16 December 2016

RE: MP 05_0147 MOD 12 Modification to Enfield Intermodal Logistics Centre (ILC)

Council has received the documentation associated with the exhibition of Modification Request No.12 for the Enfield Intermodal Logistics Centre (MP 05_0147).

Figure 2 Enfield ILC Site Showing Assessment Locations

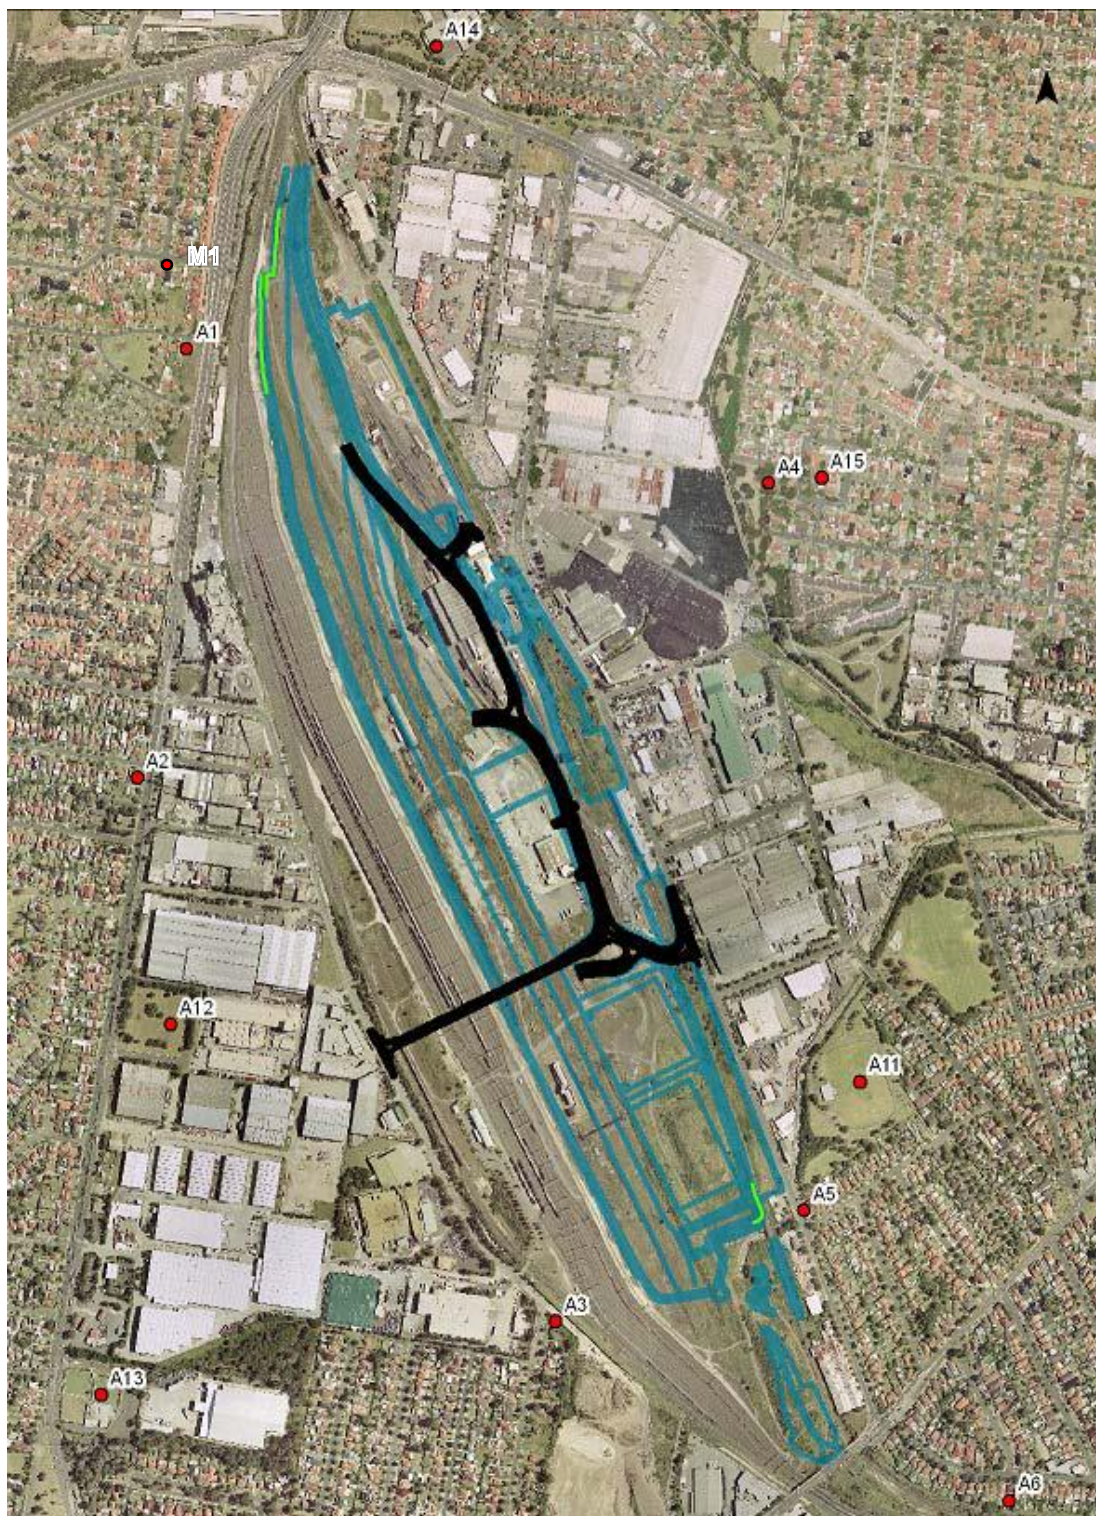
The acoustic assessment report finds that noise levels during construction may exceed the relevant noise criteria at 2 Wentworth Street and at the western end of Blanche Street.

Council requests that residents in the affected areas be given reasonable notification of works that exceed the noise criteria, their duration, total building time, provisions for minimising noise at these times and notice of when respite periods will occur. Notifications should also include an accessible contact point for complaints.

SEDP231A

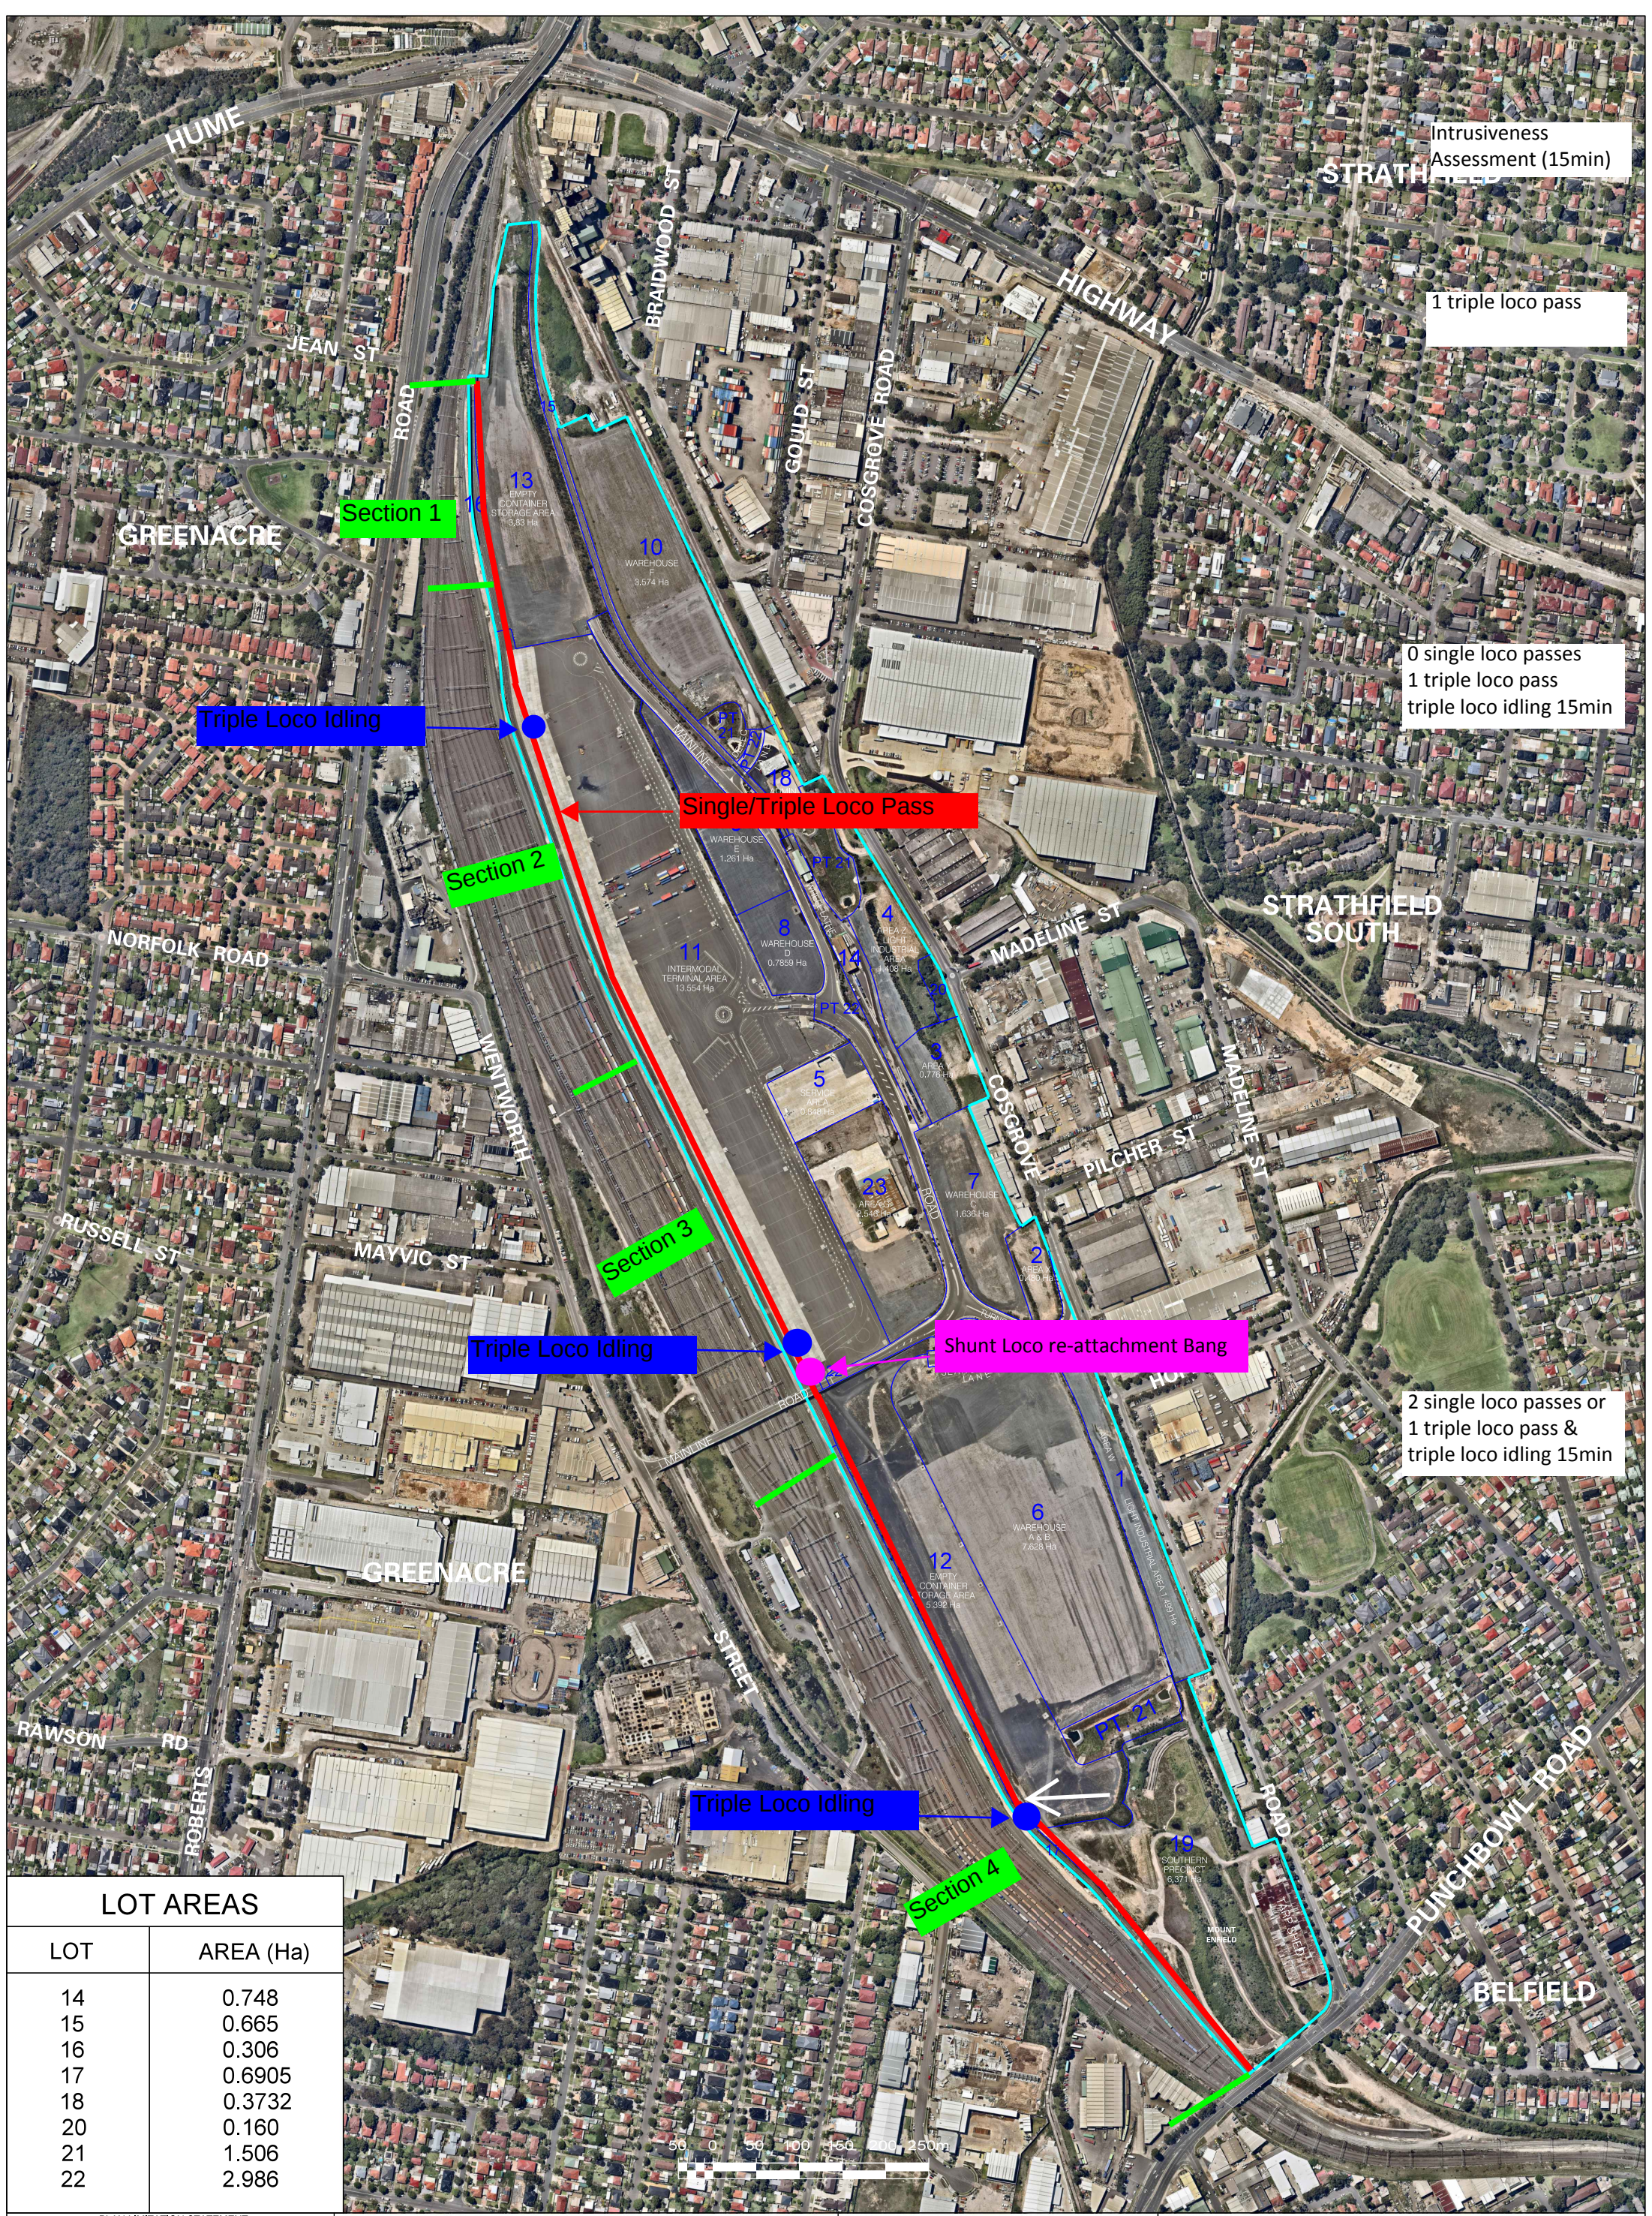
Council is concerned about the proposed extension of the rail sidings to the south due to the proximity to adjacent residential areas and the potential amenity impacts. Impacts of concern include:

- Acoustic impact during construction and operation (see comments below);
- Failure of the application to assess additional lighting needs and potential light spill during construction and operations.

While modification 12 states that the proposed extension of the rail sidings into the empty container storage area is to "*provide a wagon storage area for pre-loaded and out of service rail wagons*" Council is concerned that the siding extension alongside the container storage areas will encourage the use of these areas for overflow loading and unloading of containers. This use would be contrary to the original approval and constitute a use of the site that is substantially different to the original approval (i.e. empty container storage area). Any modification approval should include a condition limiting intermodal activities to the Intermodal Terminal Area only.
